FINAL DEVELOPMENT PLAN

JUDGE ORR ROAD RV PARK AND STORAGE

File number: PPR-16-040

SHEET NO.  
**DP5**  
 5 OF 7 SHEETS

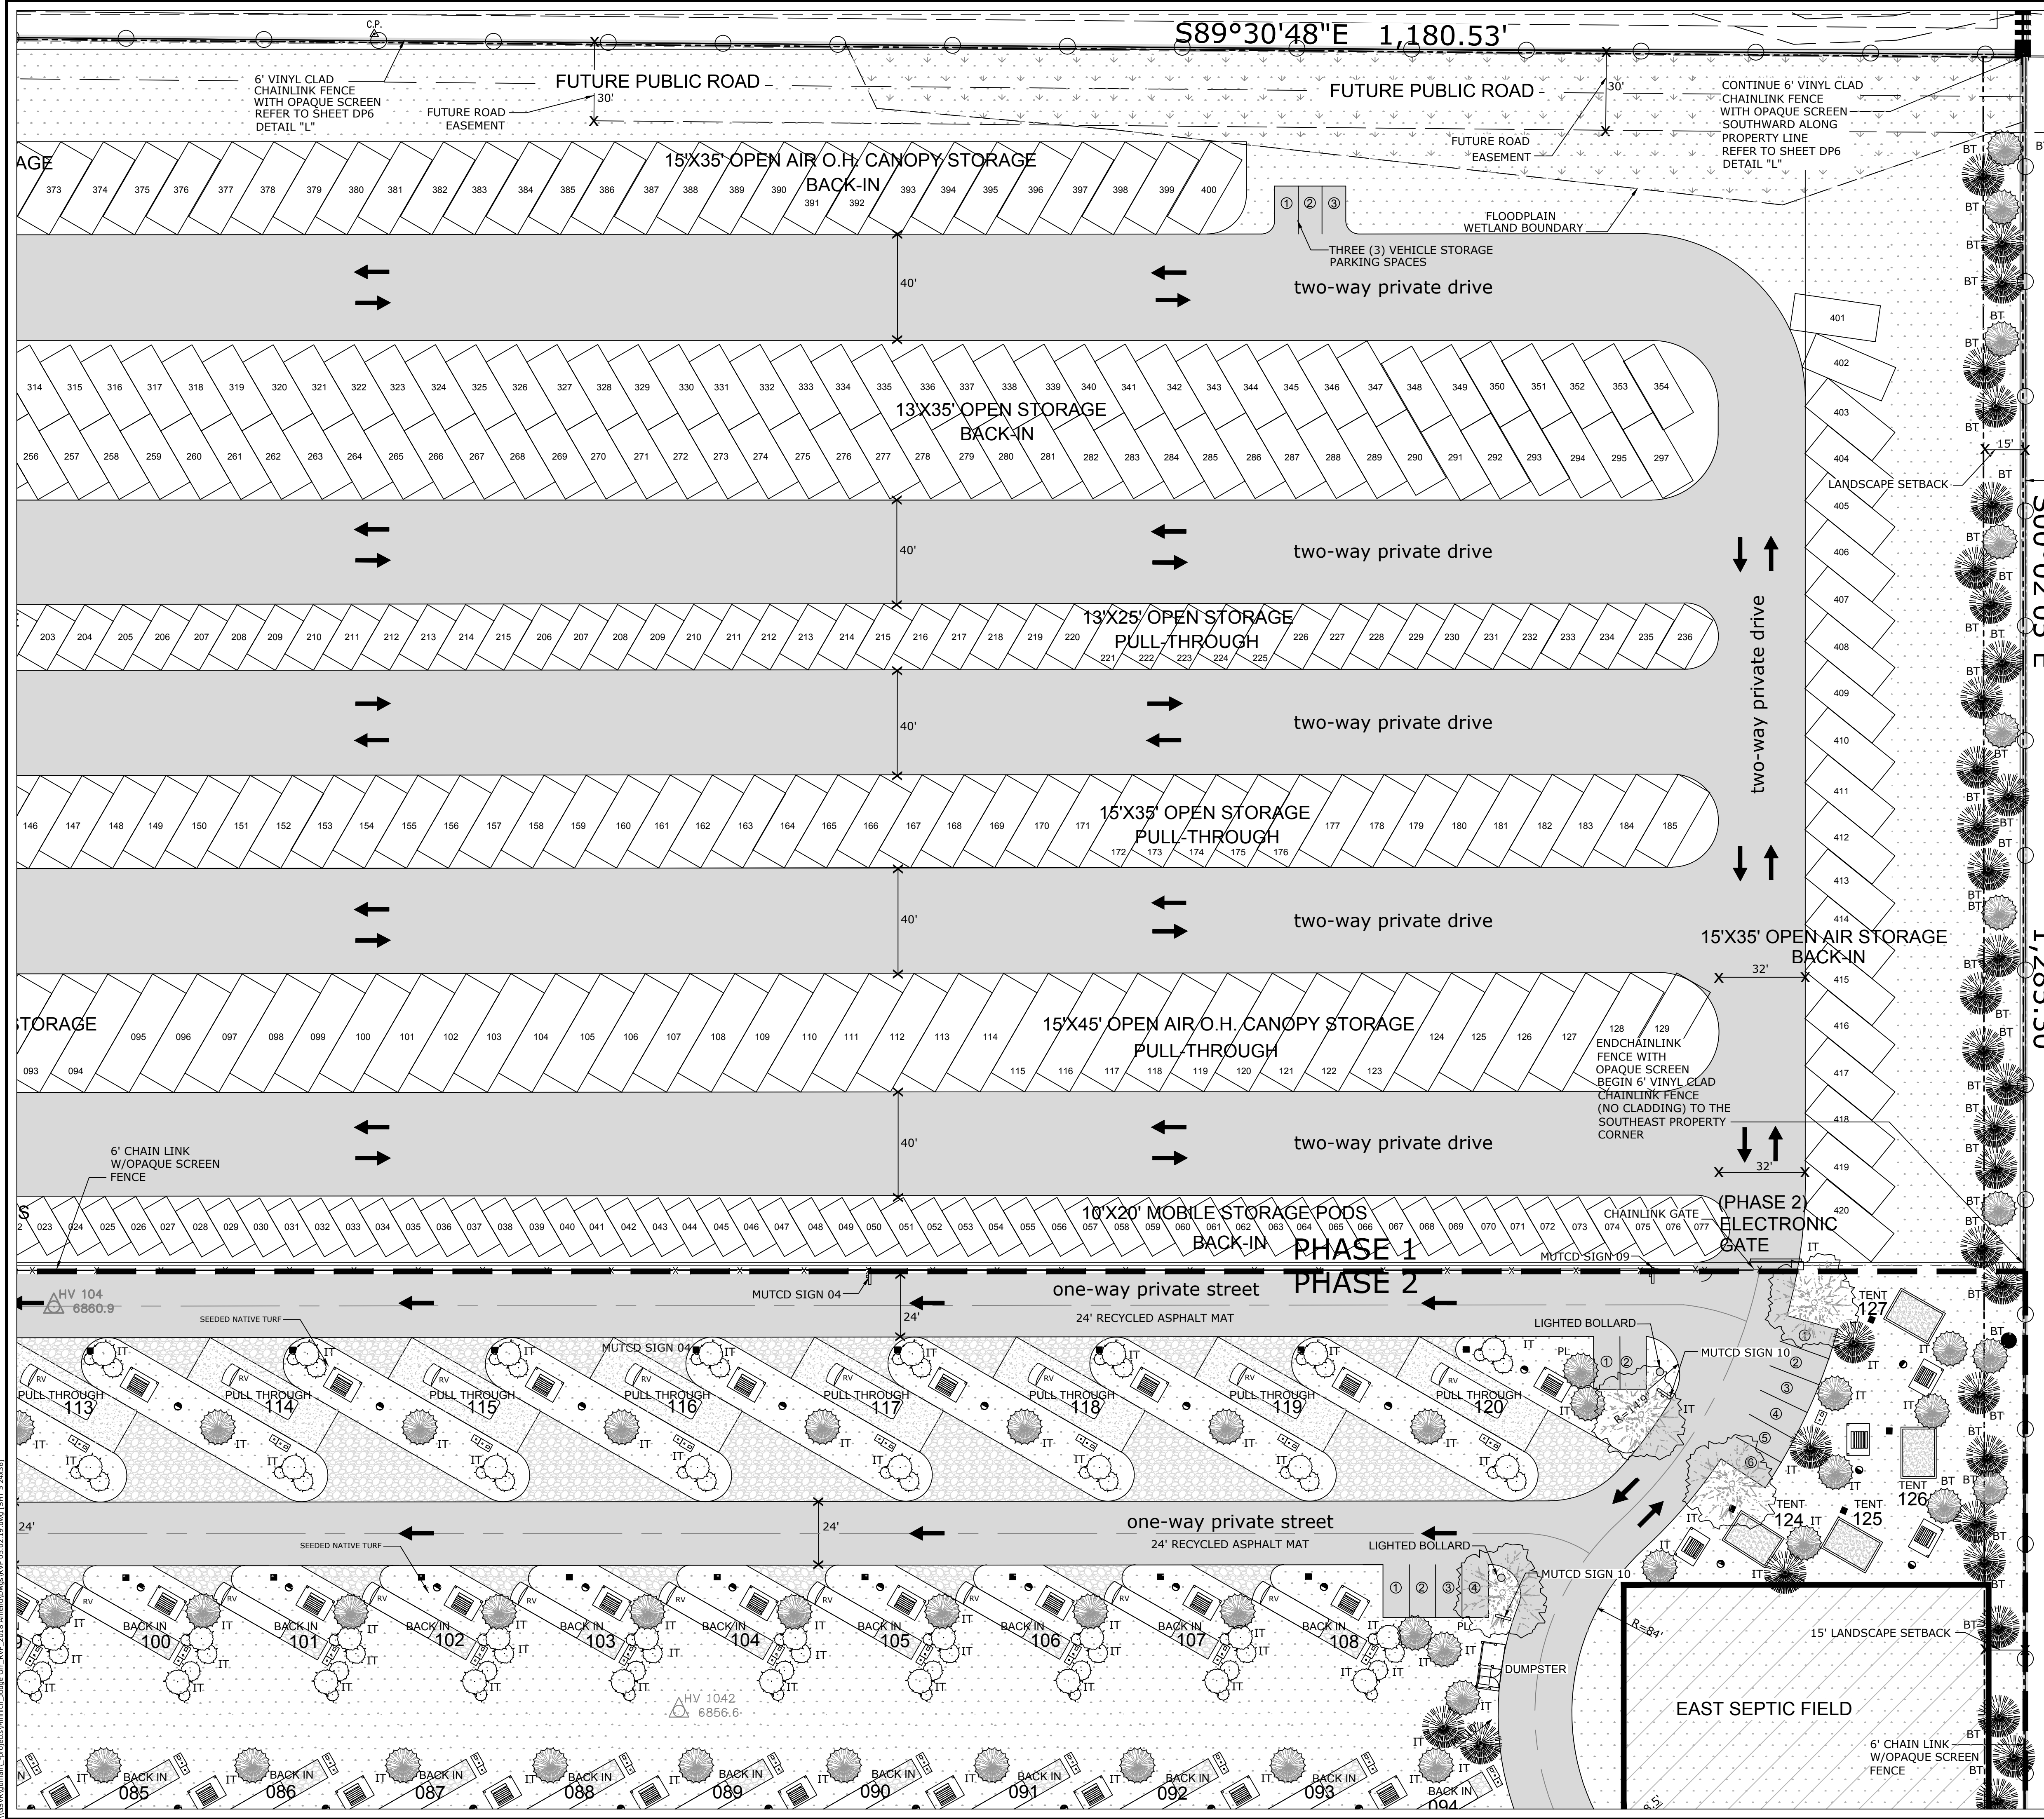
Is this supposed to be a knock box for the fire department?

When the applicant proceeds with the subdivision process a ROW stub extending to the northern property line would be required, however the roadway does not need to extend to the property line.

Consider revising this to a T-Intersection since there is no connection to the road. If the applicant plans to build the road to the property line, then a temporary turnaround would be required when the applicant requests to dedicate the road to the County for ownership/maintenance.

Unless there is a specific reason to restrict access to future lots at these locations, remove the driveway cuts. The locations would be determined/reviewed with each individual site plan applications.

TIS to provide recommendation for the gate location. Design of driveway must ensure sufficient queuing without blocking the road.
